## SEAS D7 RESPONSE to D6 submissions

SEA LINK: EN020026  
DEADLINE: 6 – 29 April 2026

# Technical Note

**Subject:** Deadline 6 submission review

Figure 7-1: A12 Seasonality – SCC ATCs

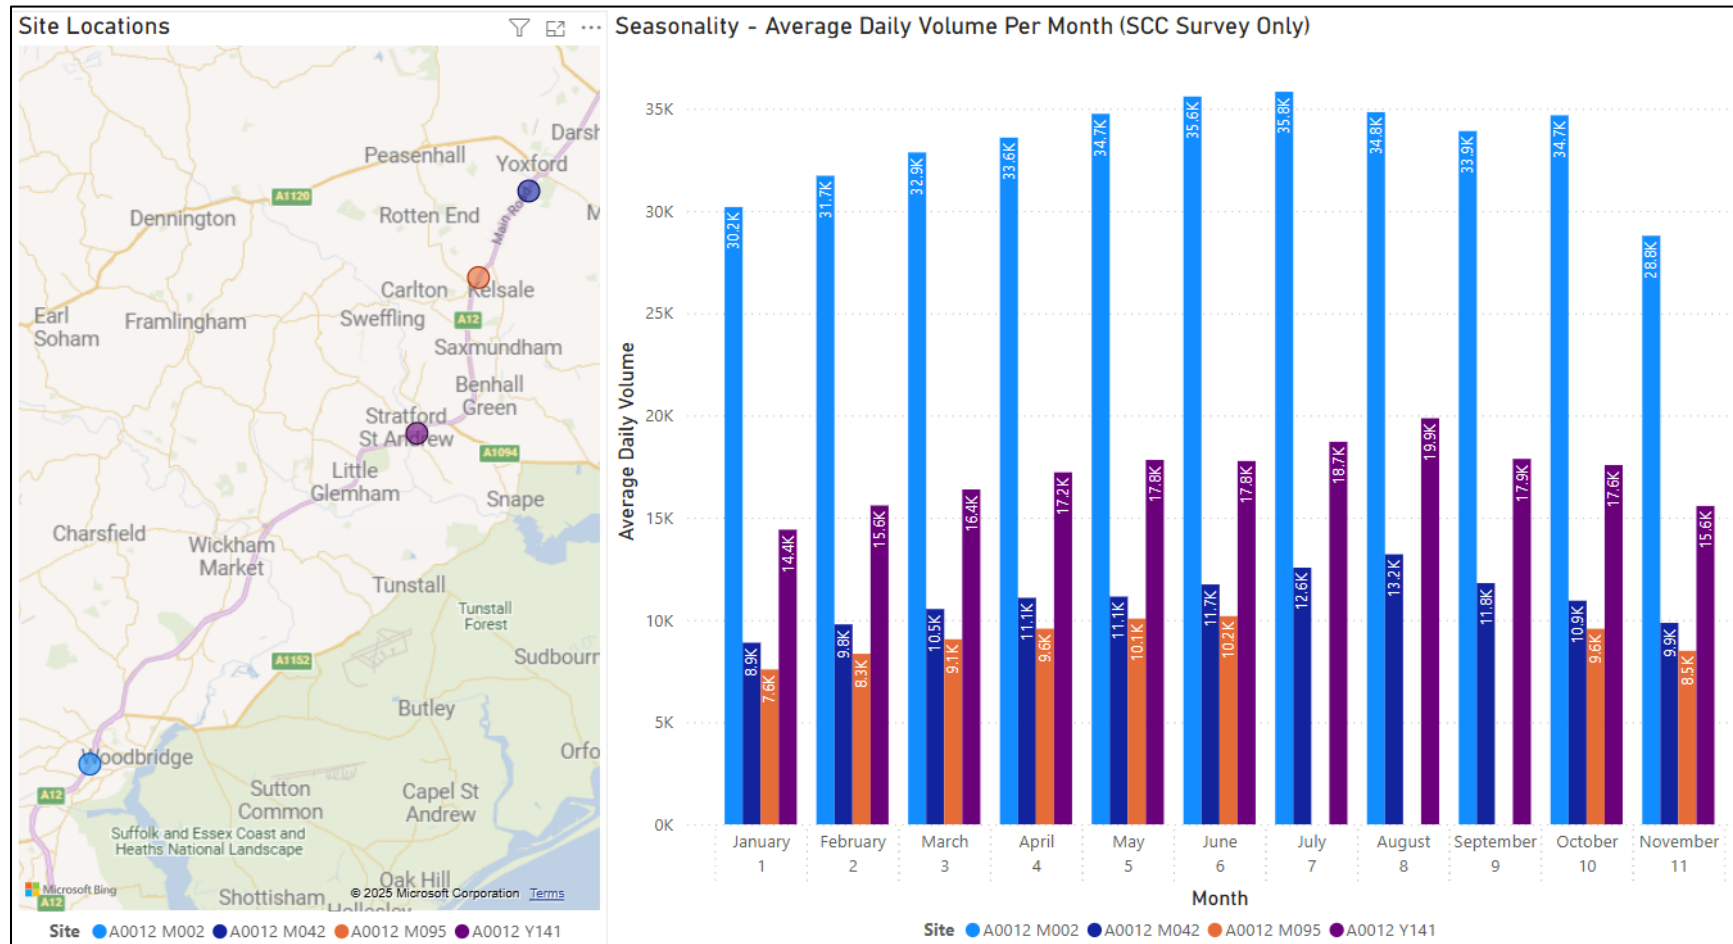
- 2.3.3 Using the general rule of thumb that the peak hour flows would be 10% of the daily flow, based on these levels of demand the flow on the A12 would be between 5,000 and 11,000 trips per day.
- 2.3.4 As set out in our June 2025 Transport Report (**document reference 07705/A**), which informed the SEAS Relevant Representation [**RR-5210**]. Flows on the A12 in the vicinity of the junction appear much higher than forecast in the junction modelling.
- 2.3.5 Figure 2 below, extracted from our June 2025 report shows typically daily flows on the A12.

2.3.6 Flows at the nearest ATC location to this junction range from broadly 14,000 to 20,000. With an average flows of 17,000 vehicles per day at this location, again using the 10% rule, one would expect flows at the junction to be c1,700 vehicles per hour. In the busy summer months this would increase to c2,000 vehicles per hour.

2.3.7 This discrepancy is such we would question if the base flows used are correct. Notwithstanding that, even if they are, it is evident that the use of non-neutral January/February data is considerably underestimating traffic flows at this particular location.
